From: Laura Gibbons
Sent: 04 April 2019 11:19
To: Planning.Responses
Cc: Simon Davis
Subject: RE: Planning Consultation on BN/14/19/DOC

Engineers Comments Regarding Condition 3- Surface Water Drainage Design

Registered: 29-MAR-19
Site Address: The Cottage Piggeries Church Lane Barnham PO22 0DB
Description of Works: Approval of details reserved by condition imposed under ref BN/19/18/PL relating to Condition No 3 surface water drainage.

© This drawing is copyright It may not be copied or reproduced without written authority			
Scale	As shown	At original	A3
Drawing Number	2014/SK2		Revision -

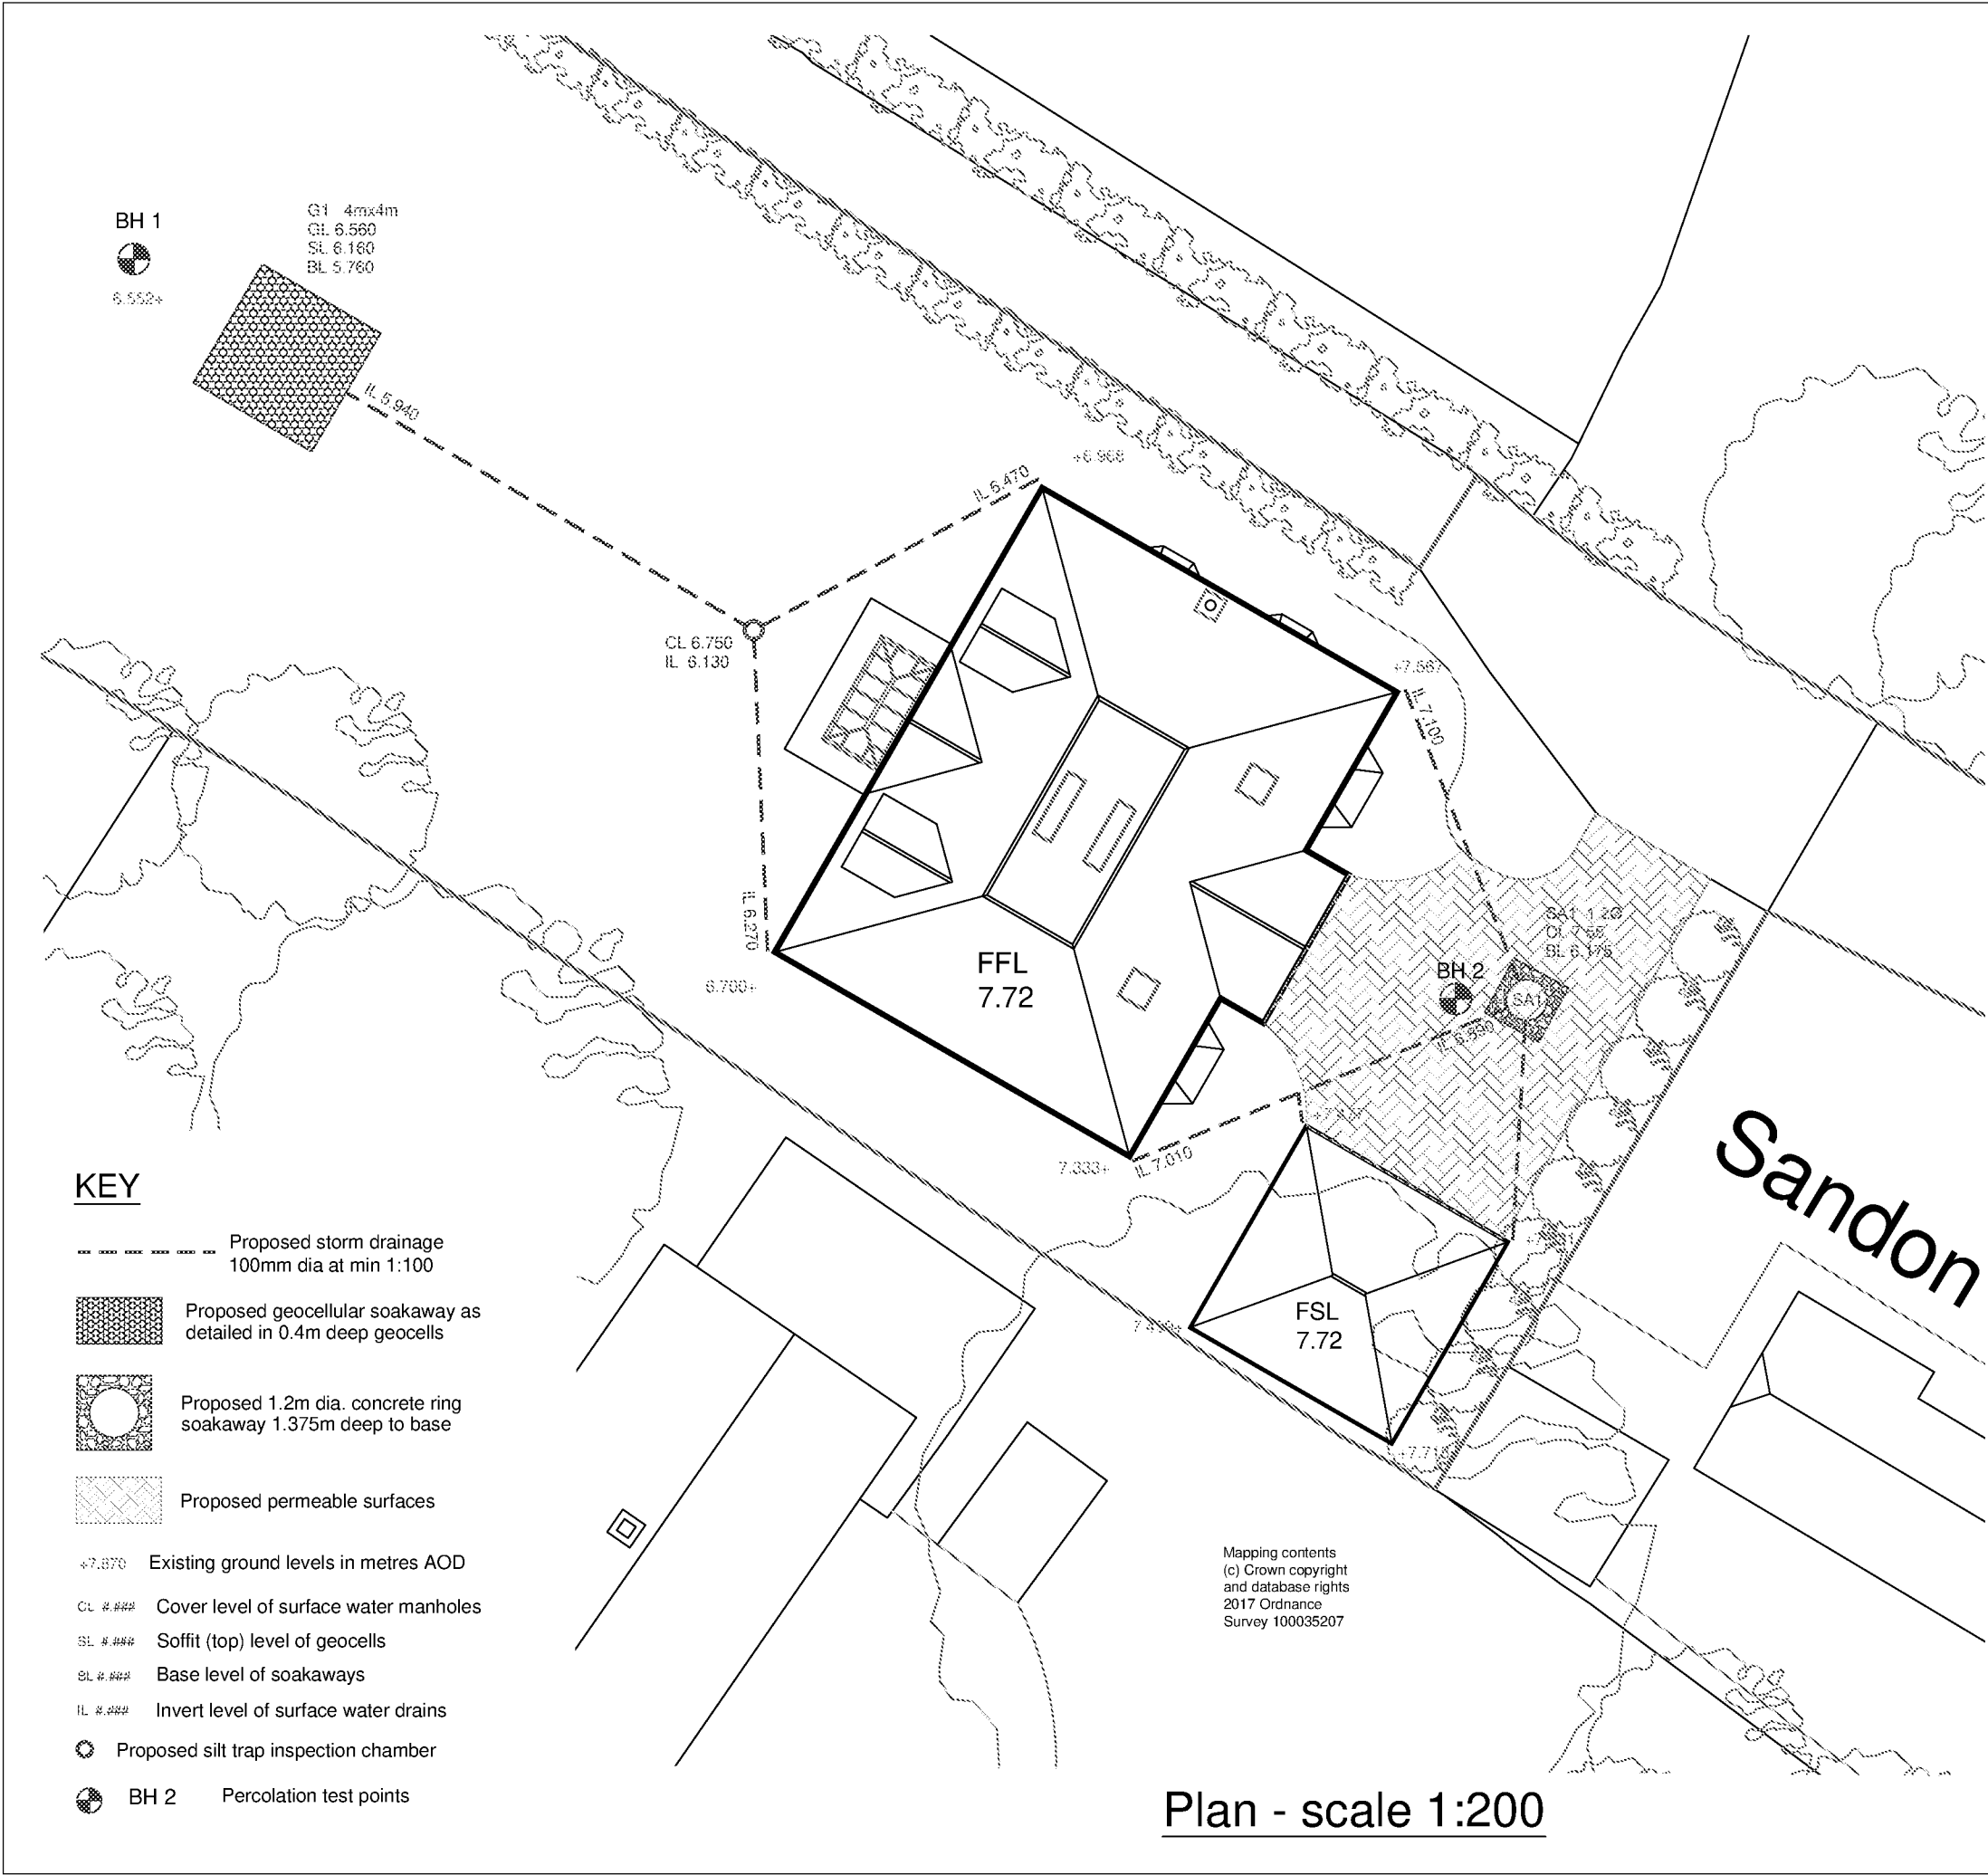
Winter groundwater monitoring and infiltration testing has been completed. The highest groundwater levels encountered were at 0.79m depth. It is unclear at which of the three monitoring locations that this peak occurred. Please can this be confirmed.

The soakaway that is proposed to be located in the rear garden has an invert level of 5.66m (0.9m below ground). The base of this soakaway must be located above the maximum recorded groundwater level, or adequate volume must be provided above the groundwater level.
